Planning Application BE/60/15/PL

In the light of the significant alterations and amendments regarding this application since 1st August 2015 please accept the as a further objection to the proposals in addition to my original objection of 27th May 2015.

| Title:-    | Proposed Floor Plans & Elevations (Plot 7&8)                                          |              |    |

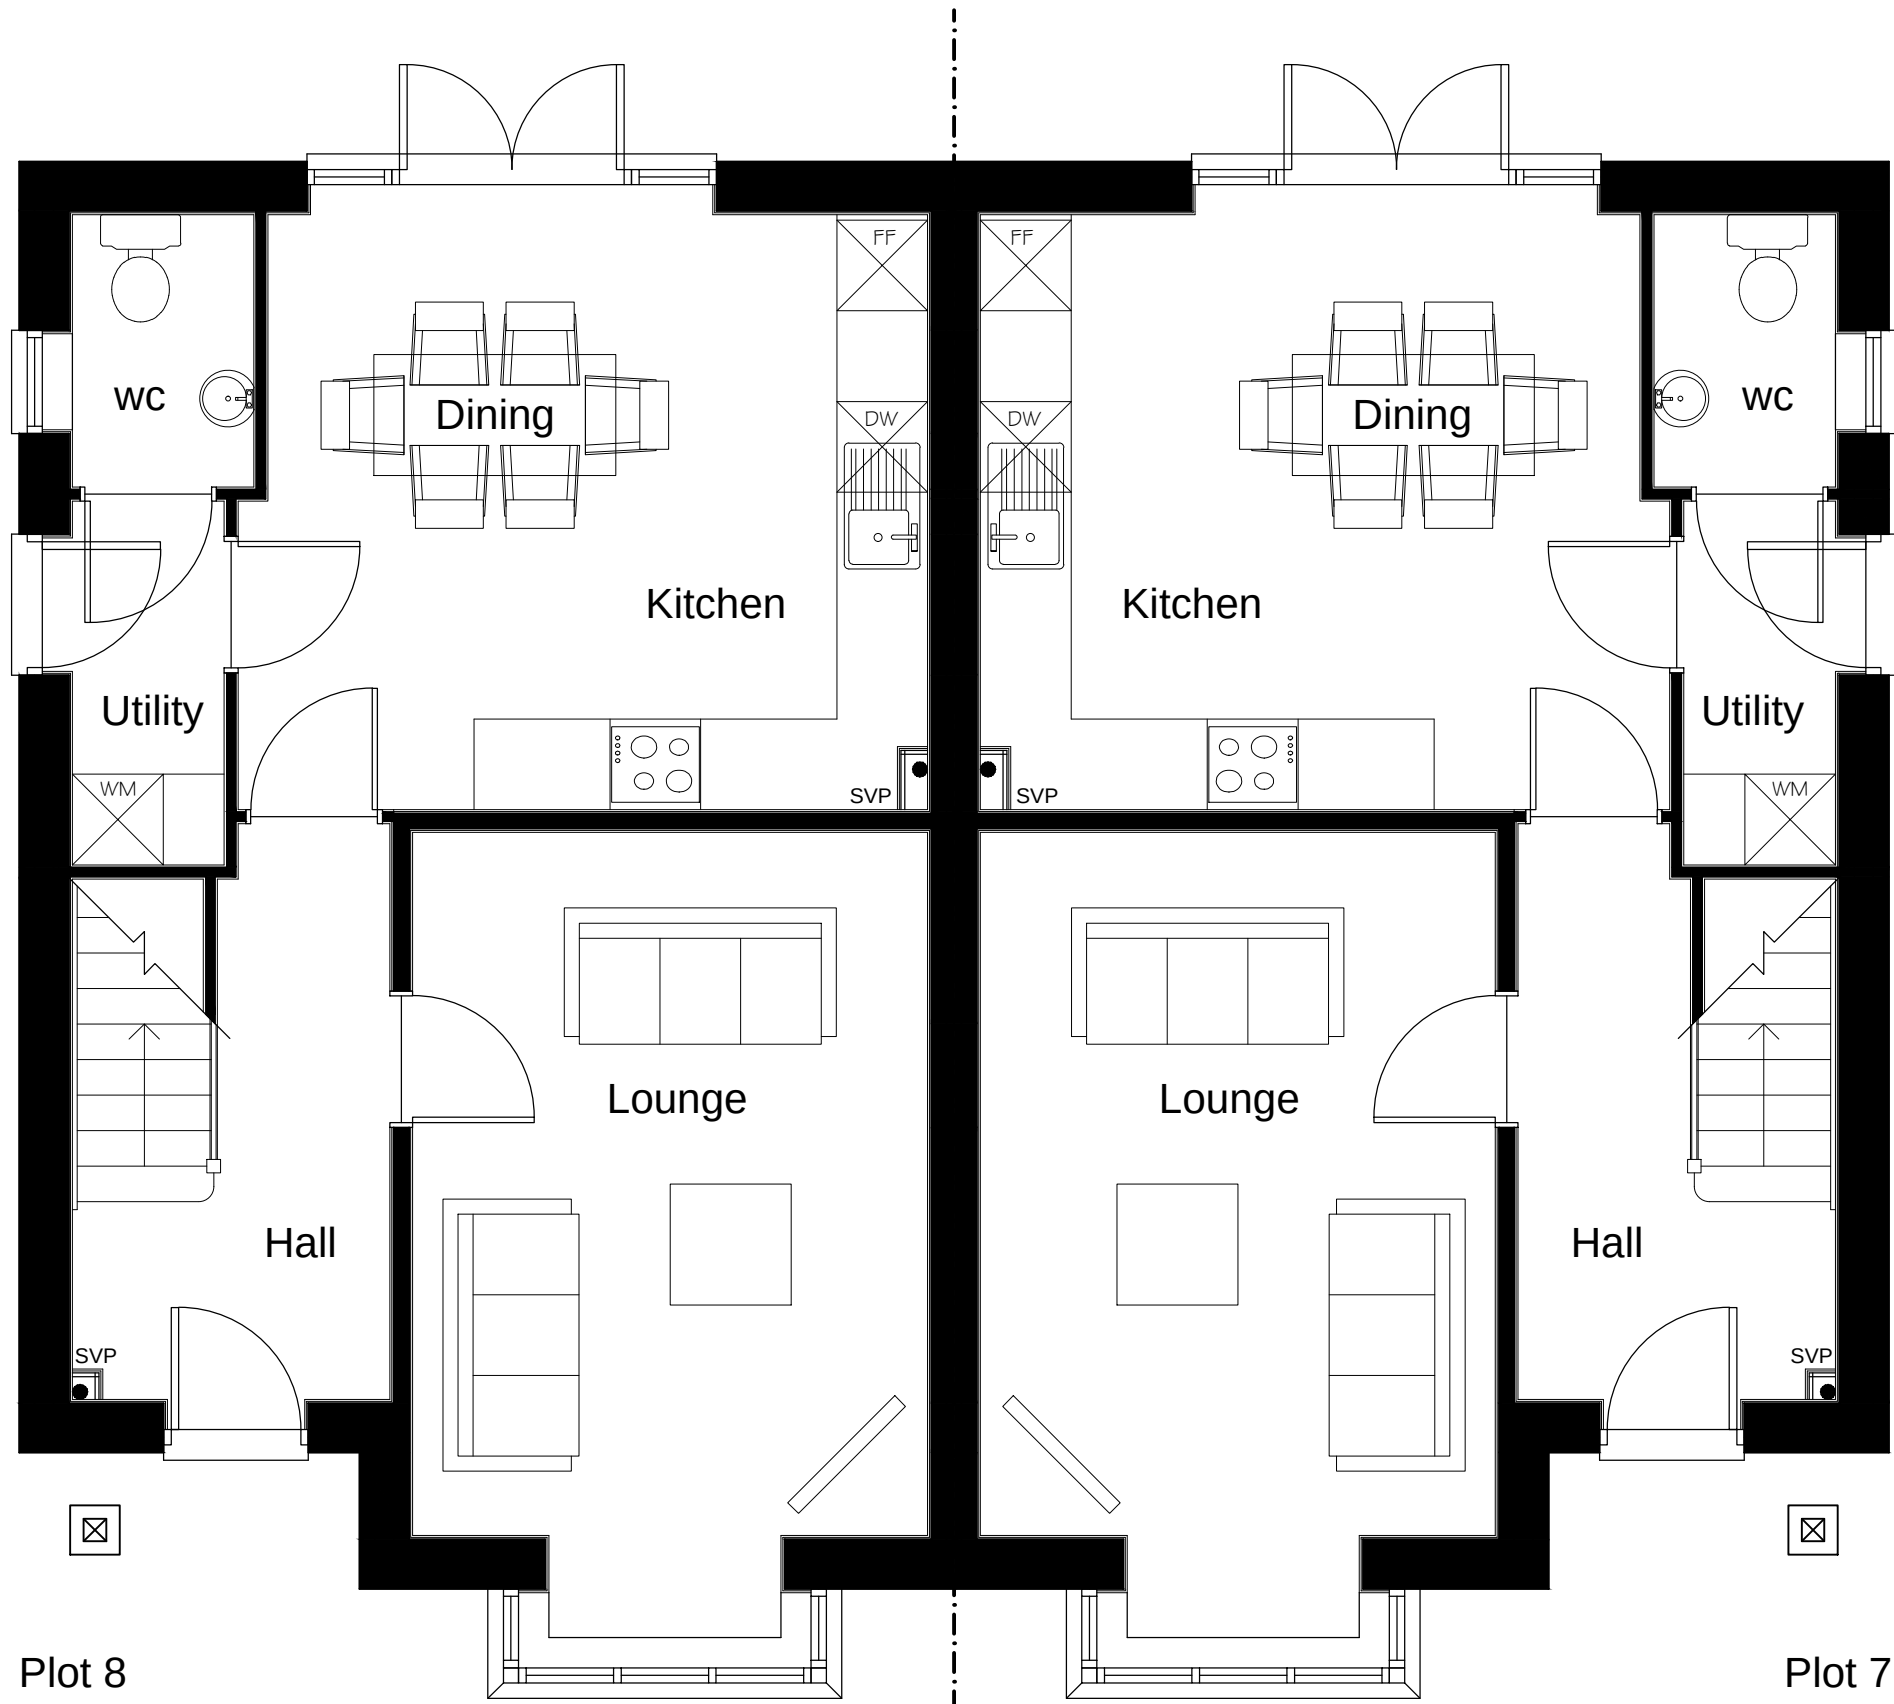
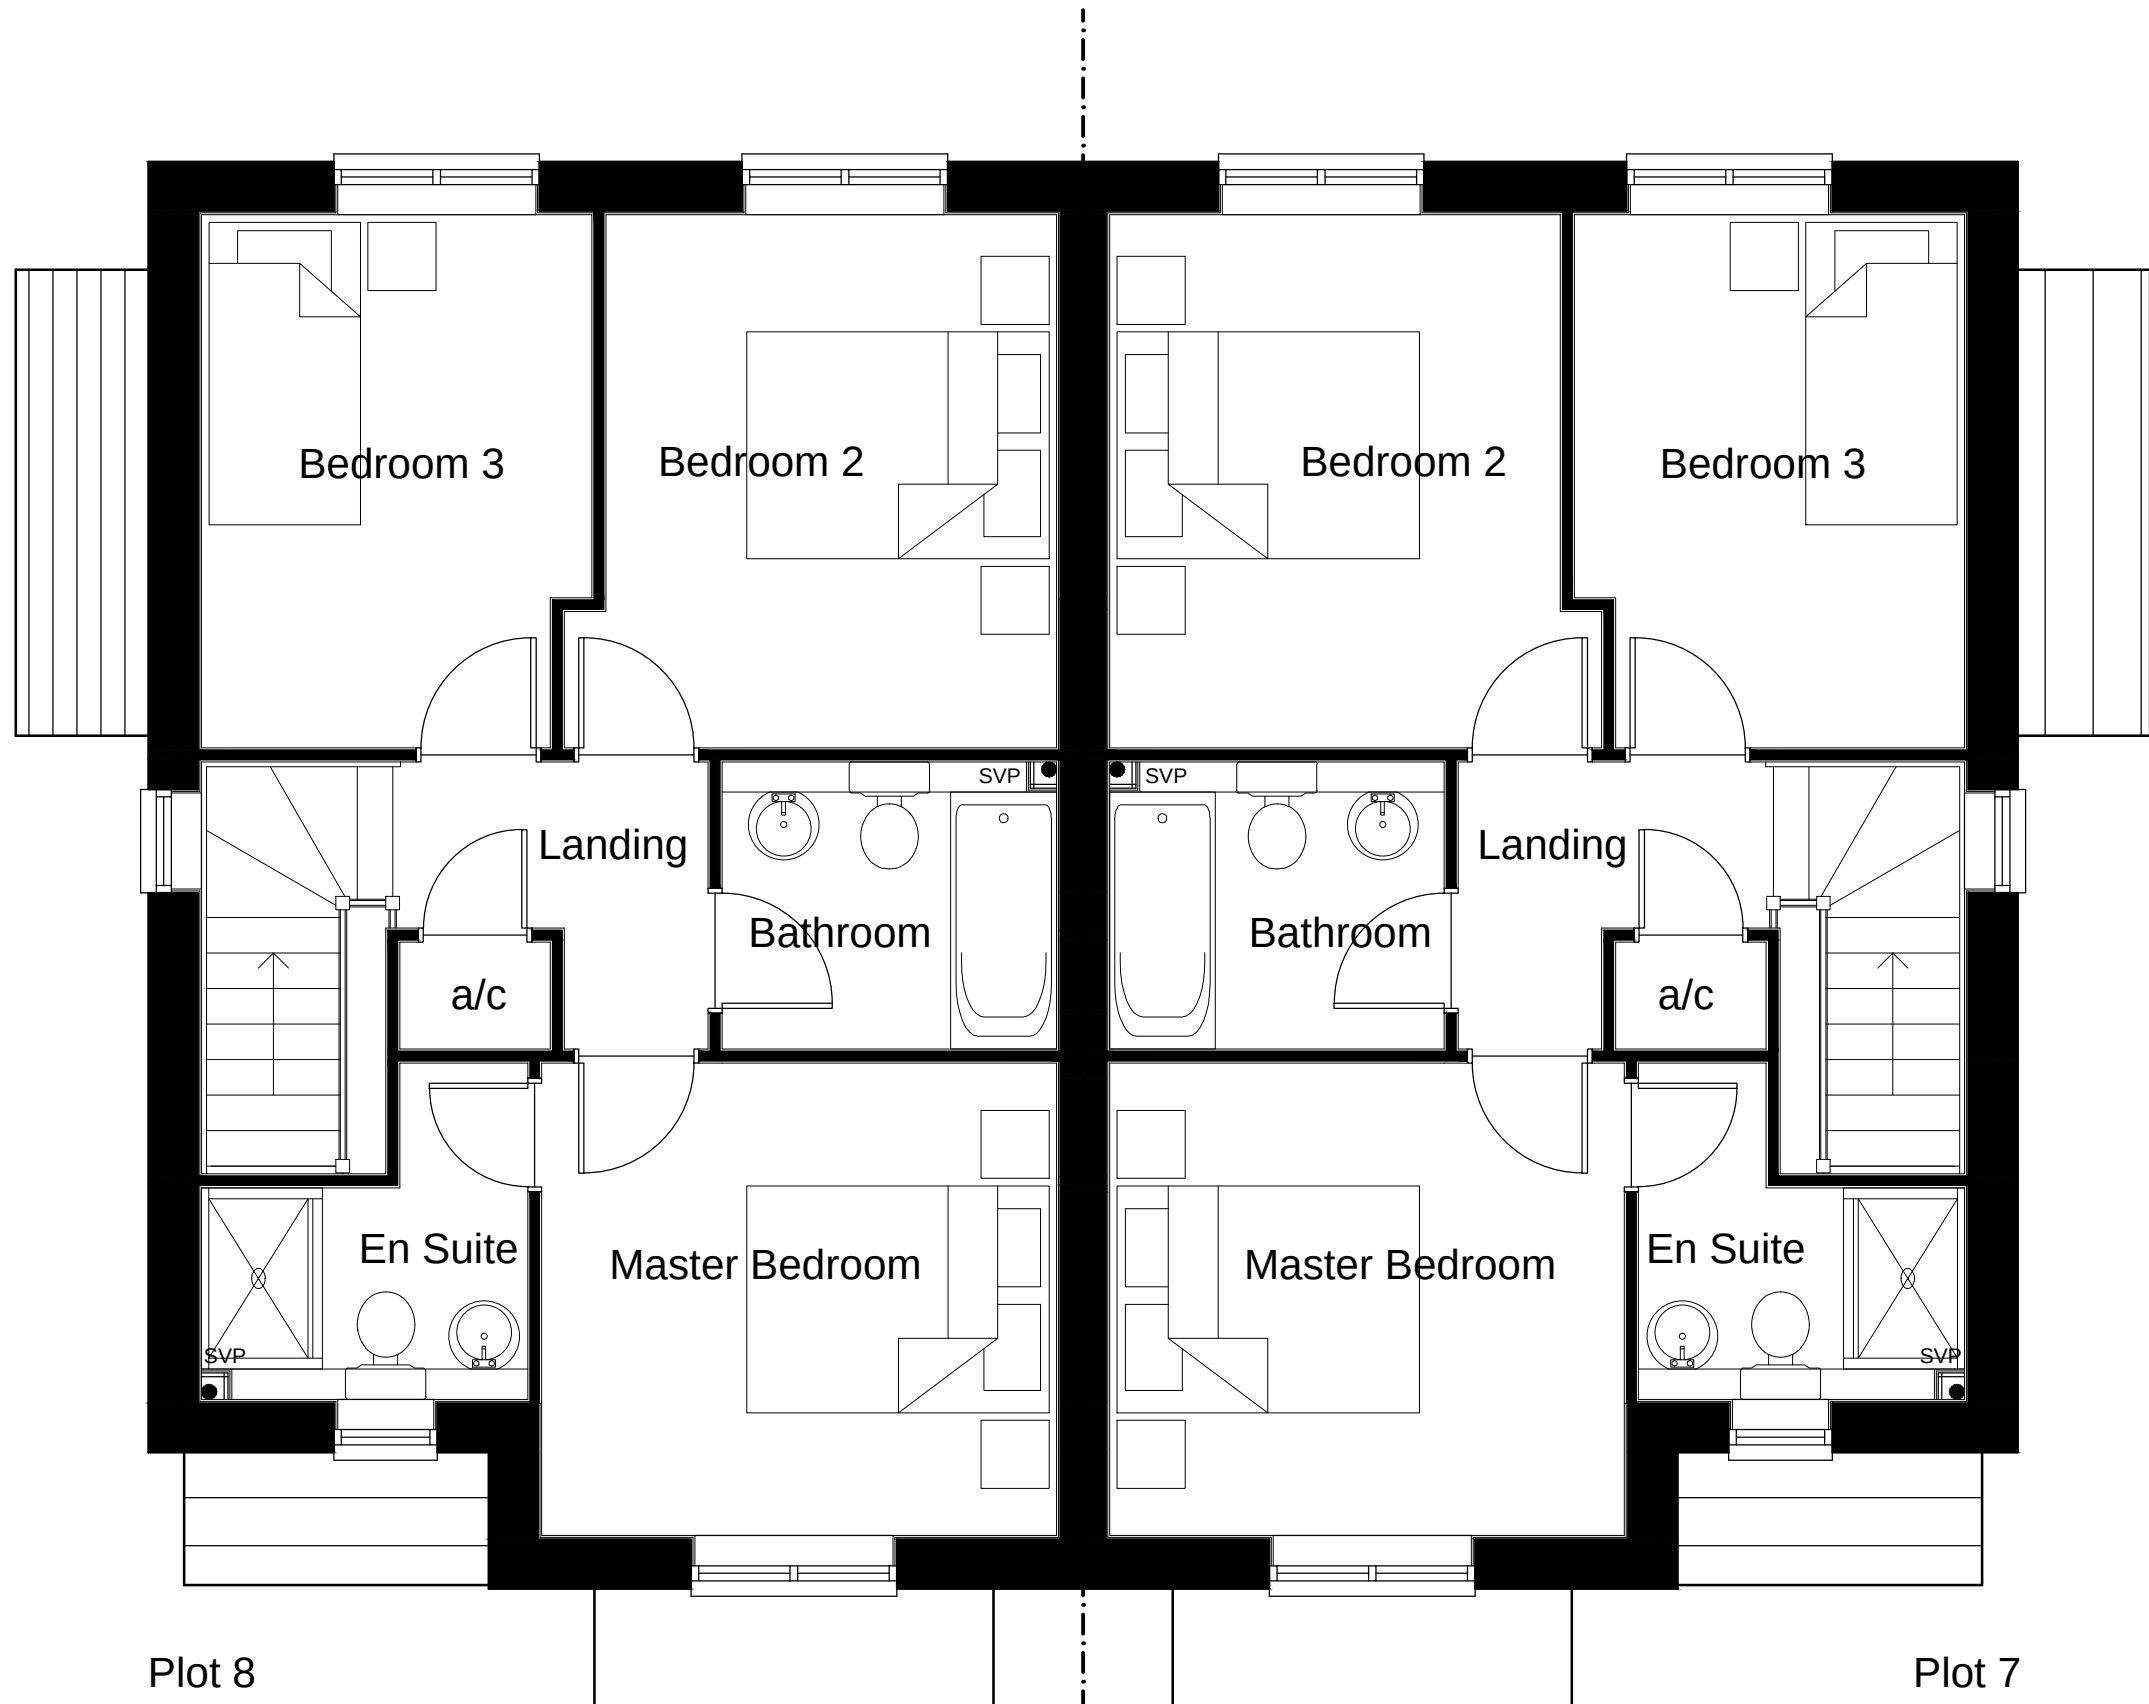
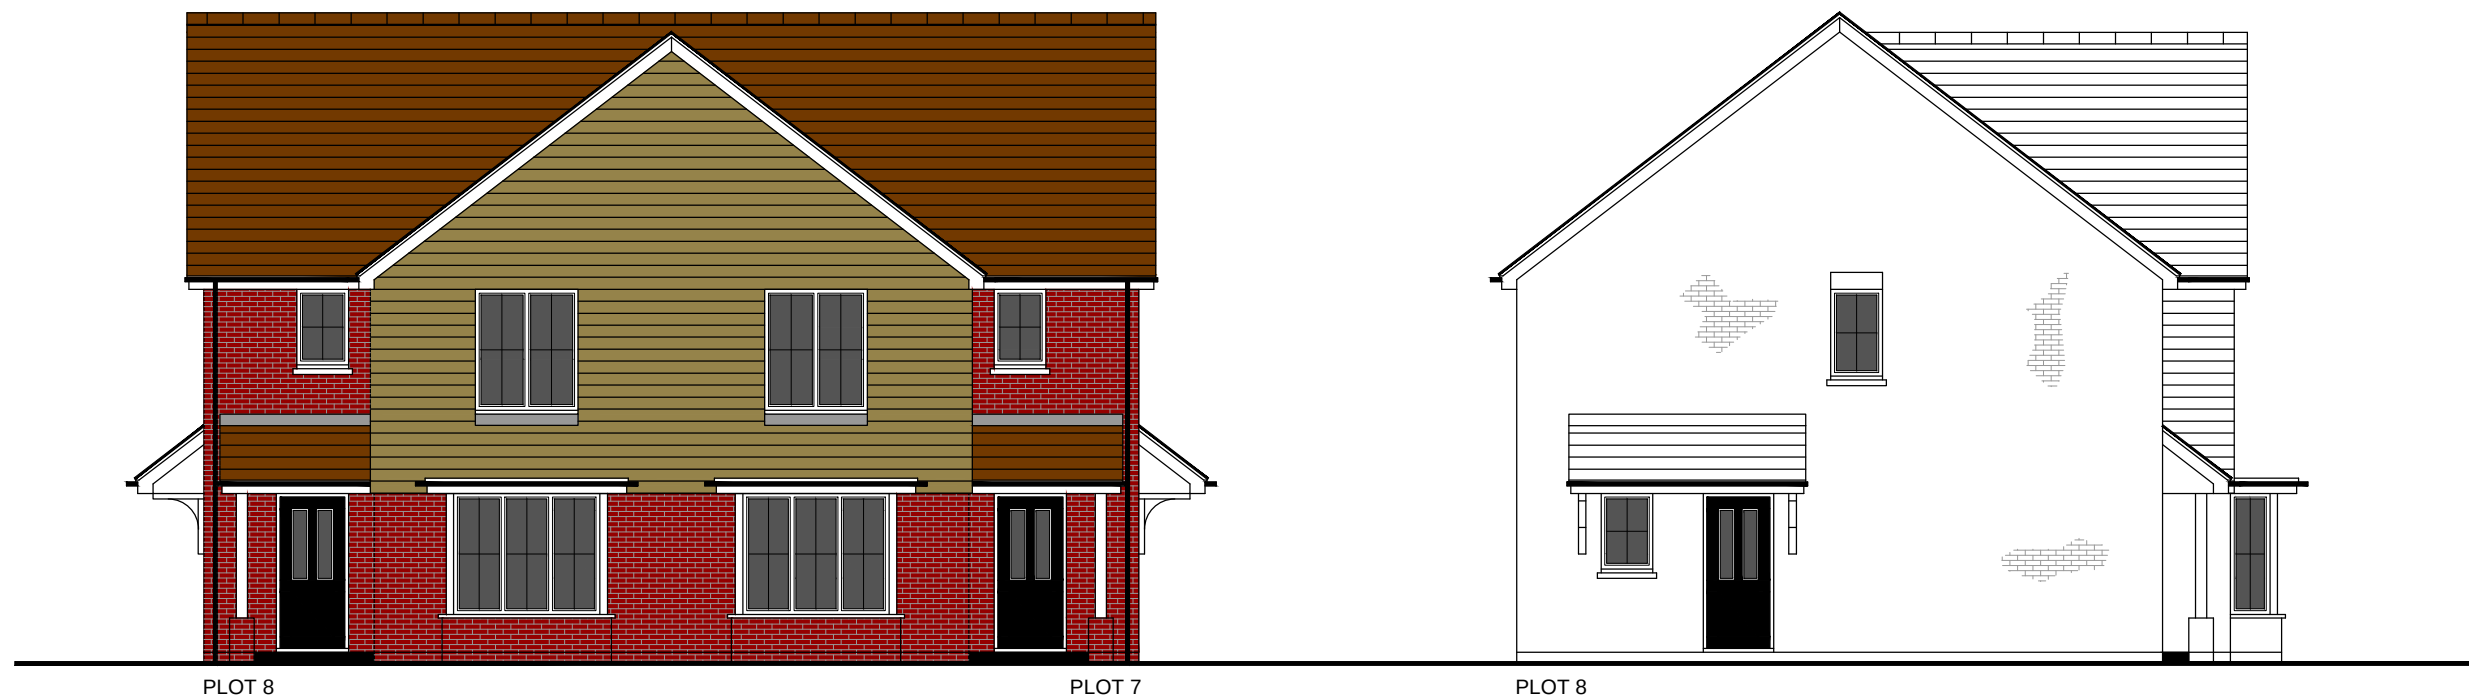
- The first floor windows comprising bedroom3, landing and bathroom of plot 8 overlook existing numbers 15 & 17. These properties are occupied by the vulnerable elderly and a young family. The windows are unneighbourly, directly compromise the privacy of these residents and would form an unsatisfactory backland development which would harm the privacy and quiet enjoyment of these neighbouring properties.

- The applicants also seek to use part of the drainage ditch to build the garages to plots 7& 8. Without those garages there is insufficient provision of parking to plots 7& 8 in contravention of the national guidance and putting increased pressure on the access road.
